Transport
Roads & Maritime
Services

WST11/000129/07

Cobbora Coal Project (MP10_0001)
Exhibition of Preferred Project Report and Response to Submissions

Proposed Road Detours and Realignments

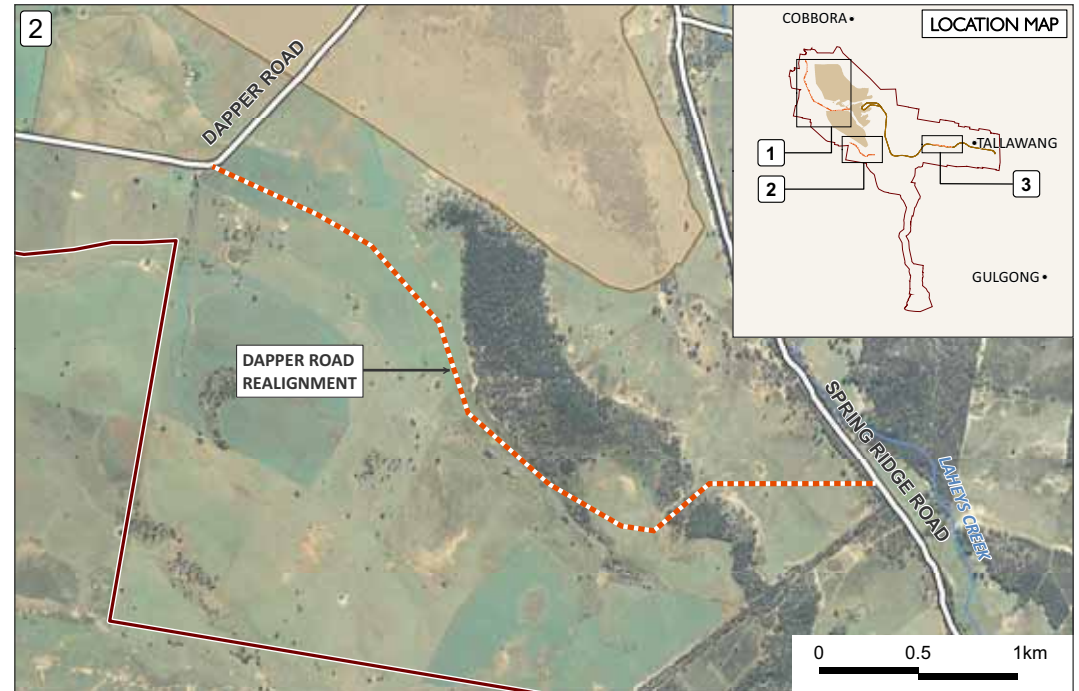
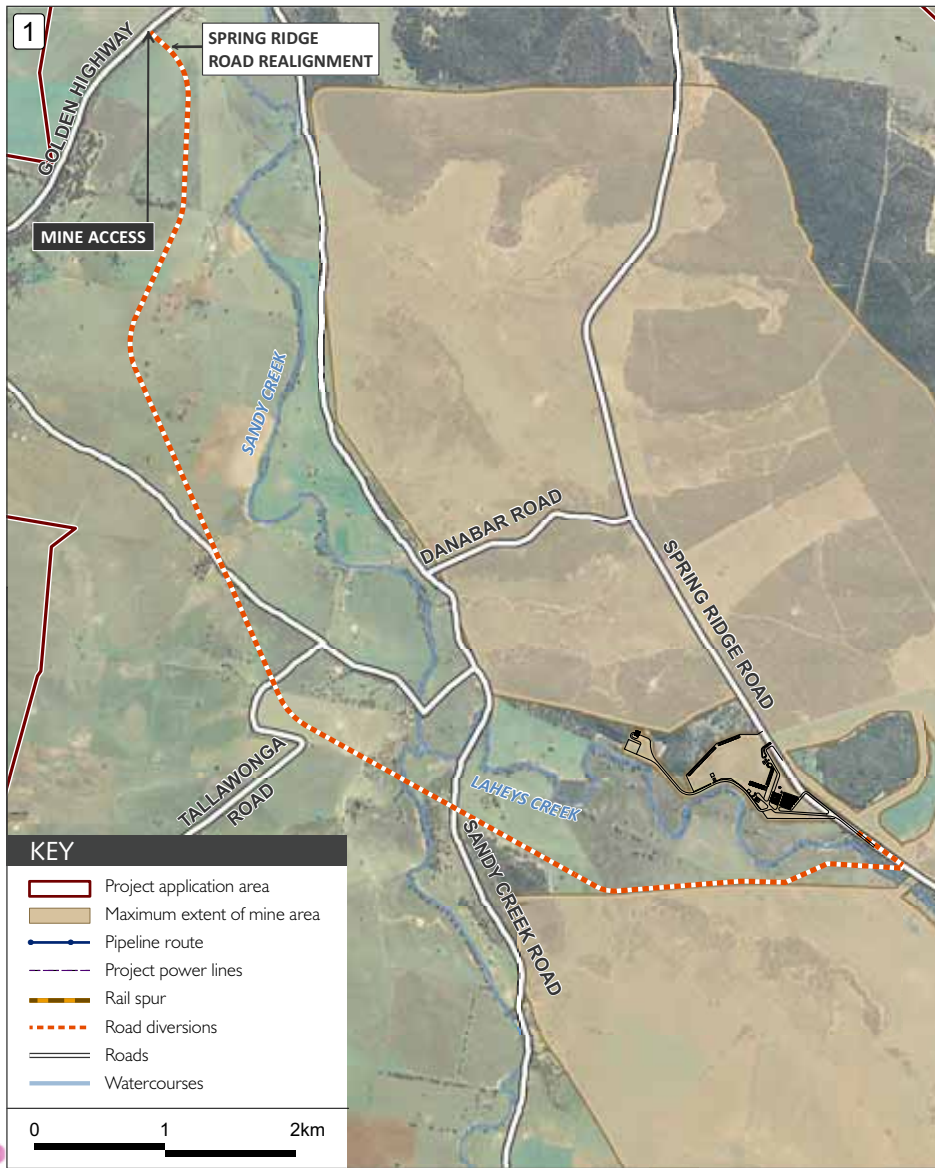
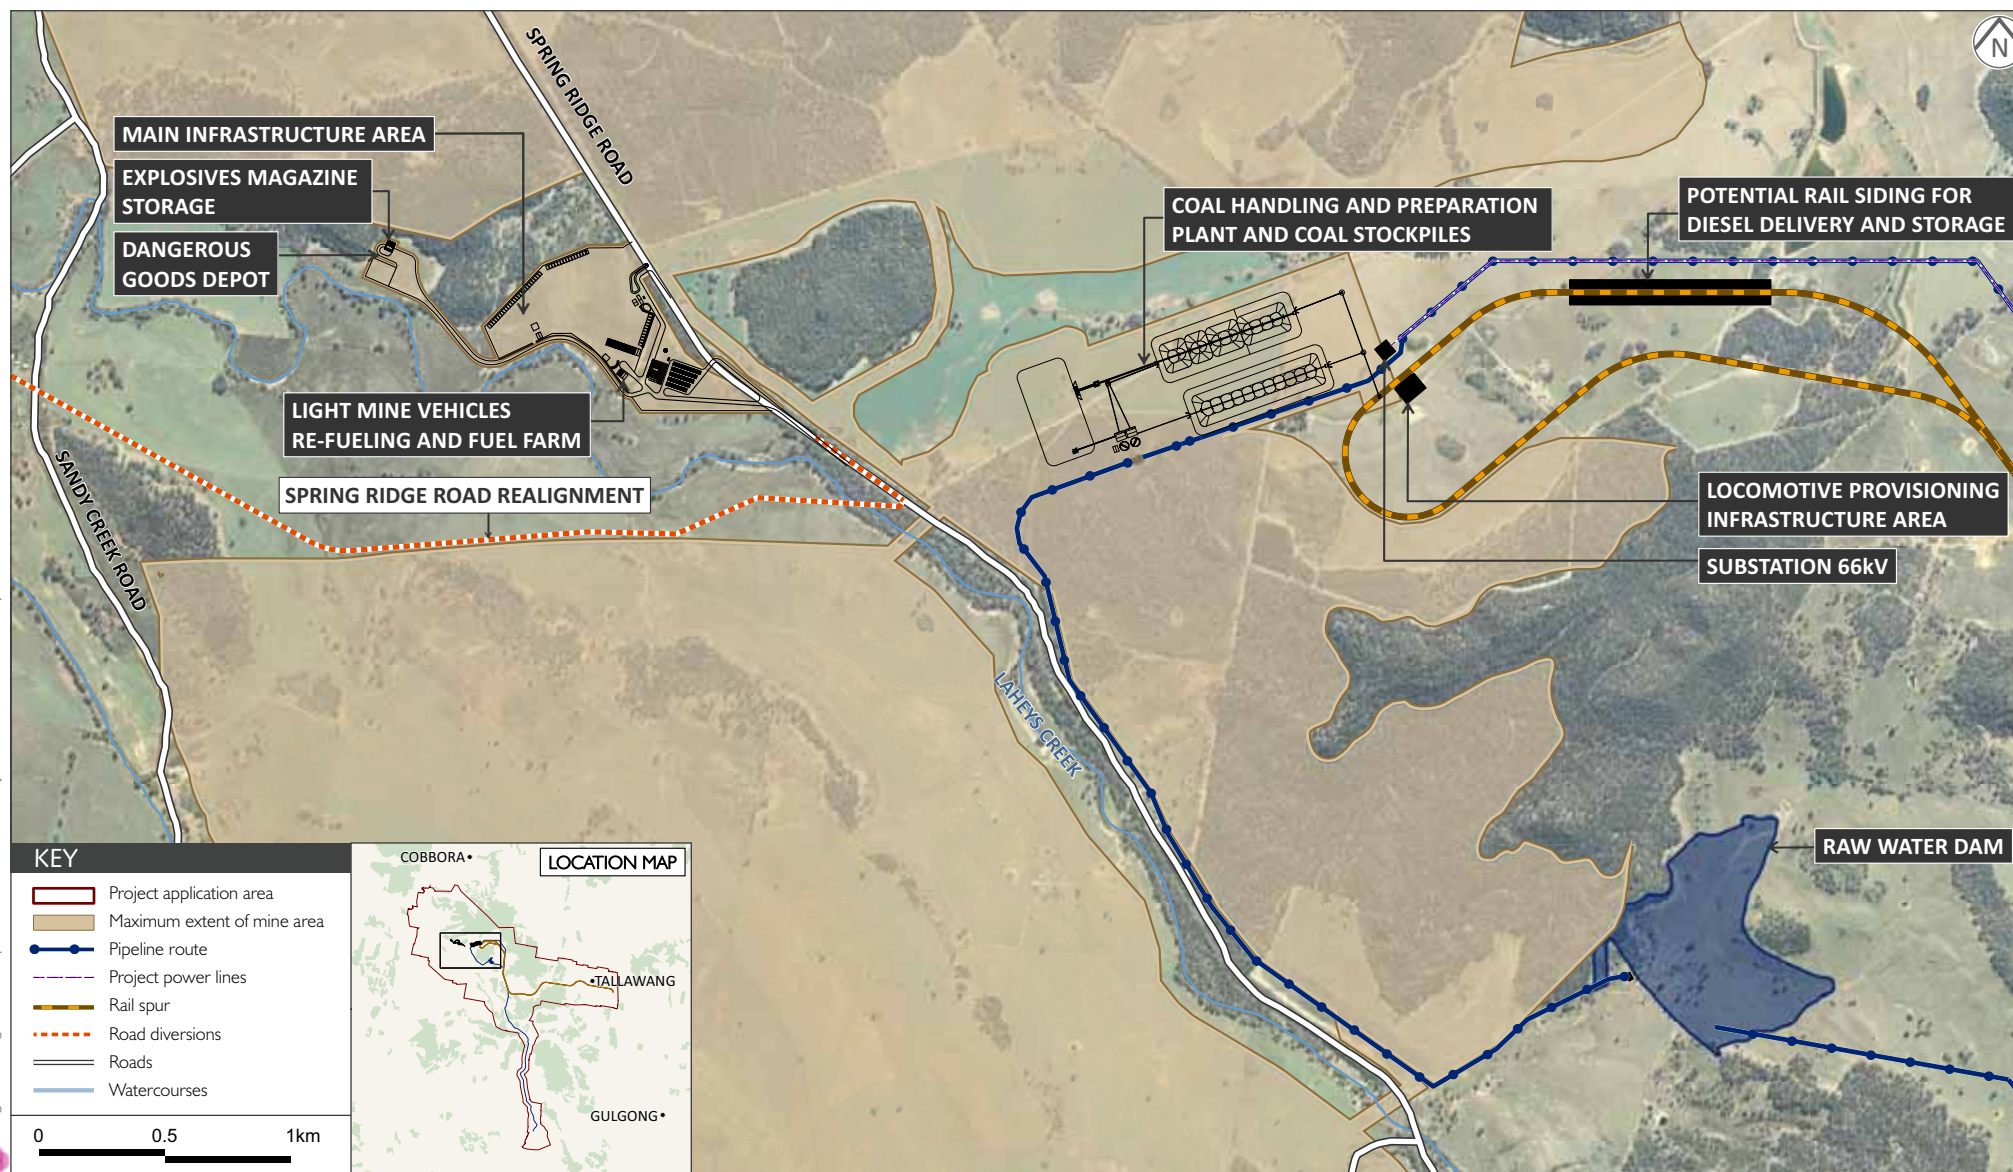
- The proposal now includes a realignment of the Castlereagh Highway including a bridge to pass over the proposed private rail line. In this regard, a temporary detour is not envisaged to be necessary as part of the new proposal;
